Rampion 2 Wind Farm

Statement of Common Ground – Historic England

Date July 2024
Rev E

Figure 1-6: Preliminary recommendations for geoaerchaeological core locations

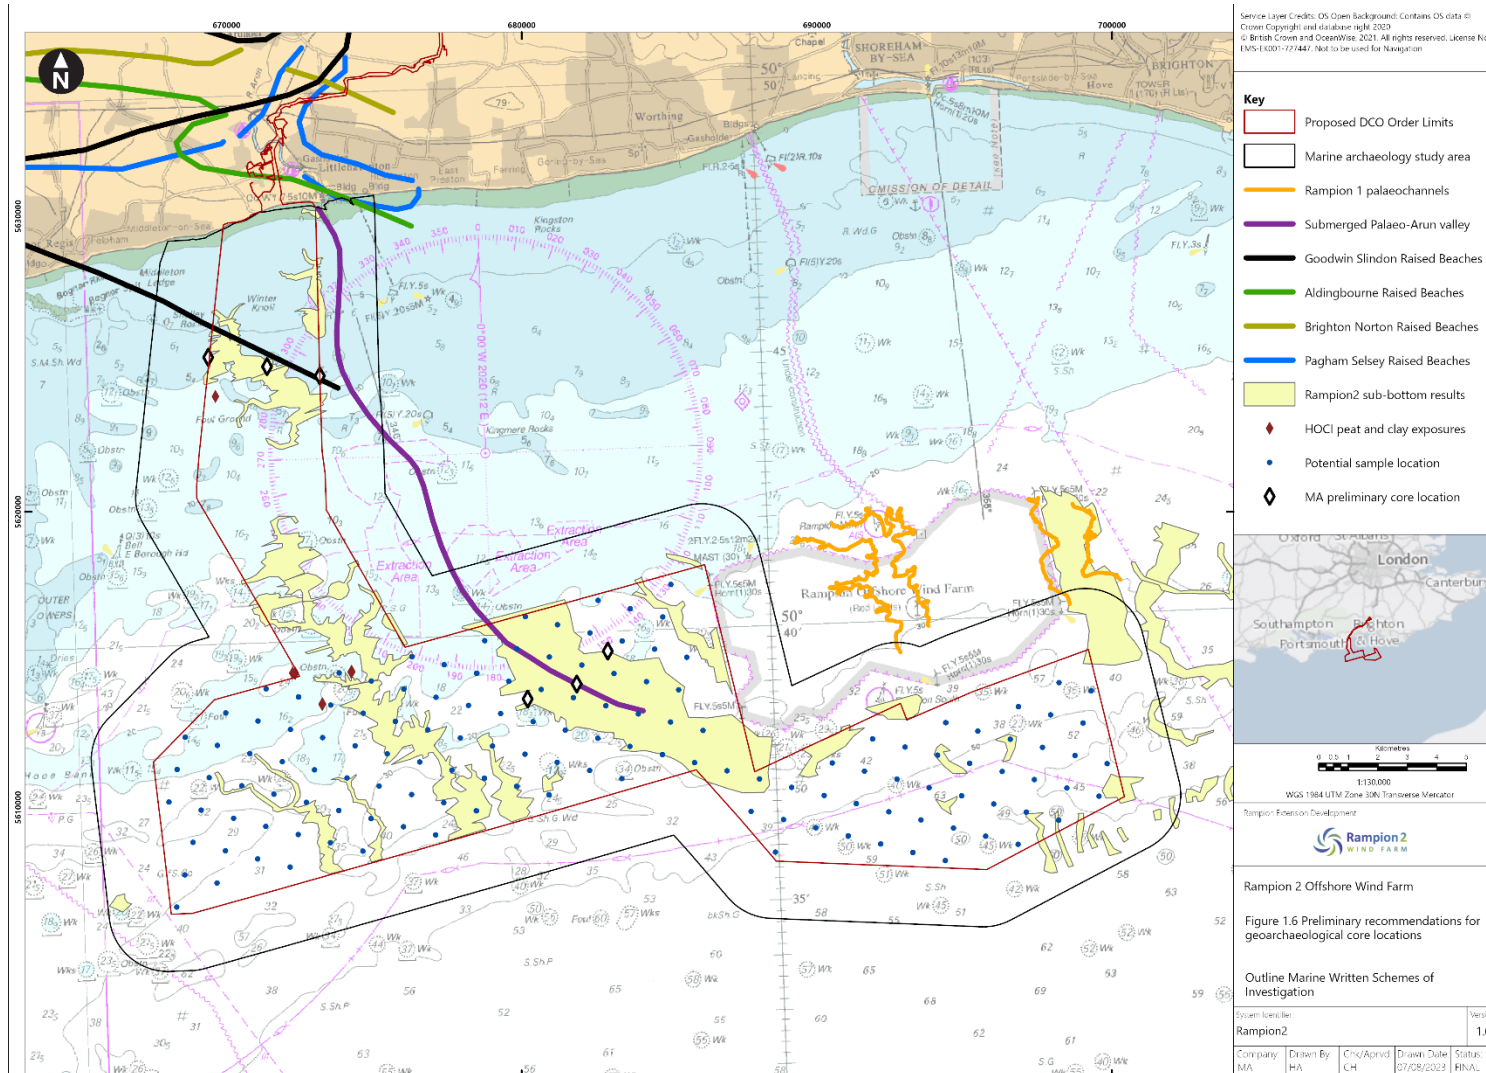
Reference Number	Matter of Contention	Historic England’s Position	Applicant’s Position	Current Status	Date of Agreement	Notes
HE4	Limitations of marine archaeology evaluation	<p>Concerns</p> <p>Historic England is aware that marine geophysical survey was undertaken in 2020 and in 2021 and Historic England concur with the Applicant that there is the possibility that presently unidentified marine heritage receptors might be discovered within the proposed DCO Order Limits which could be impacted directly or indirectly by the proposed development.</p> <p>Desired Actions</p> <p>The Outline Written Schemes of Investigation (WSI) should provide for geoarchaeological analysis of geotechnical survey materials.</p>	<p>This was discussed during the Evidence Plan Process. The Applicant declared that no geotechnical cores would be collected before the decision on development consent is granted. However, all available information will be used to ensure that the Final WSI and embedded environmental measures clearly state that archaeological input must be sought ahead of geotechnical campaigns (in accordance with C-59). The Applicant responded to this at Deadline 2 as part of the Applicant’s Response to Prescribed Consultee [REP2-026] (Reference: 11.27).</p> <p>Future geoarchaeological assessments will be undertaken using a staged geoarchaeological approach to assessment and analysis of the collected geotechnical data resulting in project reports and a deposit model. The assessments will be used to contribute to seabed mapping and modelling of submerged prehistoric landscapes, resulting in a greater understanding of the prehistoric past and the use and habitation of submerged former terrestrial landscapes. Preliminary, recommended archaeological core locations, based on the 2020 sub-bottom data and desk-based</p>	Ongoing point of discussion		<p>Advised on the 3rd of June 2024 clarified that should consent be obtained, a suitable WSI shall be produced in consultation with Historic England, in accordance with any Deemed Marine Licence, and thereby allow for subsequent survey method statements to be produced in consultation with Historic England.</p> <p>The Applicant acknowledges that all future Method Statements outlining geotechnical works will be produced in consultation with Historic England.</p> <p>Details on the methodical approach to sample collection and subsequent geoarchaeological assessment has been added to the Outline Marine Written Schemes of Investigation, [APP-235] (updated at Deadline 5).</p> <p>An updated Outline Marine Written Scheme of Investigation [REP3-041] has been submitted at Deadline 5 to address concerns raised by Historic</p>

Reference Number	Matter of Contention	Historic England's Position	Applicant's Position	Current Status	Date of Agreement	Notes
			<p>data can be seen in Figure 1-6, Outline Marine Written Schemes of Investigation, [APP-235] (updated at Deadline 3).</p>			<p>England in 'Comments on any further information/submissions received by Deadline 3' [REP4-087] (submitted at Deadline 4). The updates include;</p> <p>Removal of section 5.7.</p> <p>The text "and in consultation with "statutory historic" bodies i.e. Historic England (Generation and Transmission Assets) and West Sussex County Council (Transmission Assets)" has been added to Table 6-4.</p> <p>Section 6.5 has been updated to include possible sample methods (vibrocore and boreholes) as well as a methodical approach to the archaeological assessment of geotechnical cores. Further details have also been added to section 8.4.</p>
